Applicant's Responses to Deadline 6 Submissions

The West Midlands Rail Freight Interchange Order 201X

THE WEST MIDLANDS RAIL FREIGHT INTERCHANGE ORDER 201X
APPLICANT'S RESPONSES TO DEADLINE 6 SUBMISSIONS - DOCUMENT 17.1

Transport Technical Note 45 – Response to Connect Technical Note 02.

TITLE
2015, PM PEAK HOUR (1700-1800),
ALL VEHICLE TRAFFIC FLOWS
Version 1, 31/05/2017

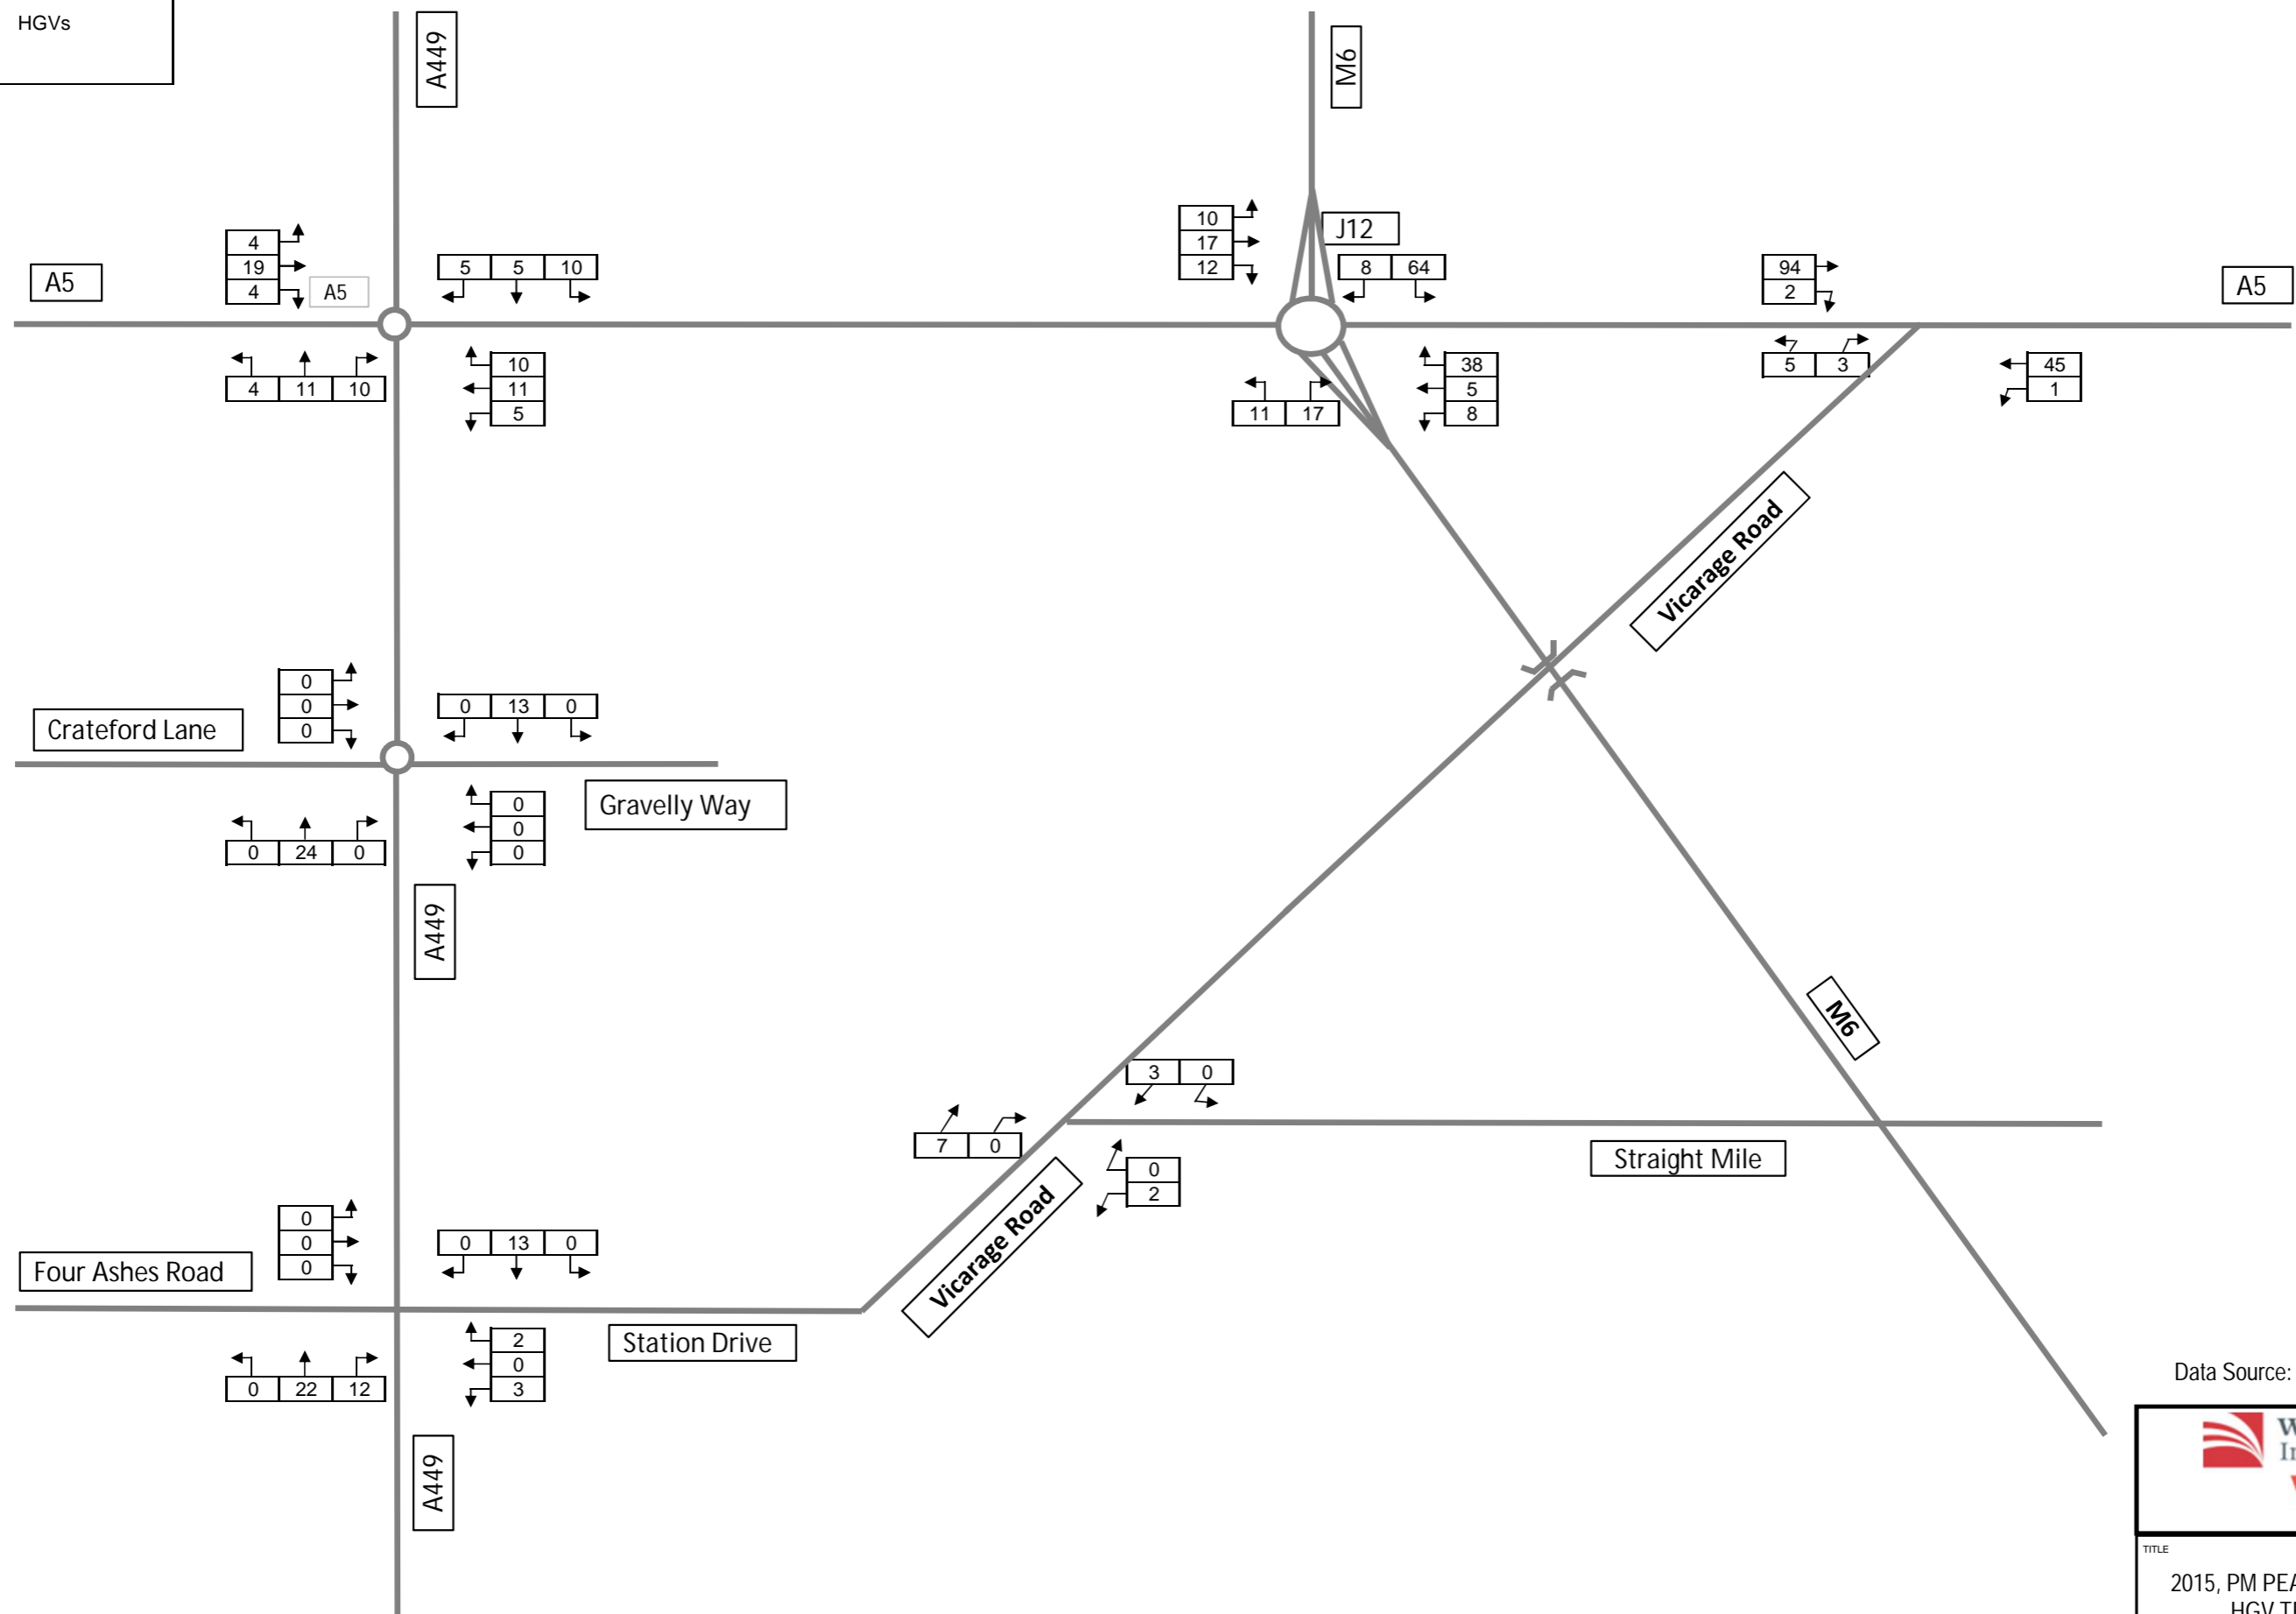
- 2.1 At paragraphs 2.5 – 2.8 of TN 02, Connect assert that there are errors in the traffic flow diagrams (APP-146) submitted with the application and call into question the reliability of the analysis. The specific issue they are referring to relates to the absence of U-turning traffic at the A449 site access roundabout in traffic flow diagrams (APP-146) included in the Transport Assessment (APP-114). WSP acknowledge that the specific U-turn movement from A449 south to A449 south is not shown on the traffic flow diagram at the A449 site access roundabout, however, the changes in traffic flows at the A449 / Station Drive junction to the south, as a result of the U-turning traffic, is included on the diagrams.

- 2.2 The junction turning movements provided to us by the VISSIM modellers (Systra) did not report the U-turn movements at any junctions, however, these u-turning traffic movements are modelled and included

2.3 Therefore, the Applicant can confirm that the traffic flows assessed and all analysis presented is correct and there are no errors. This position has been accepted by both Highways England and Staffordshire County Council.
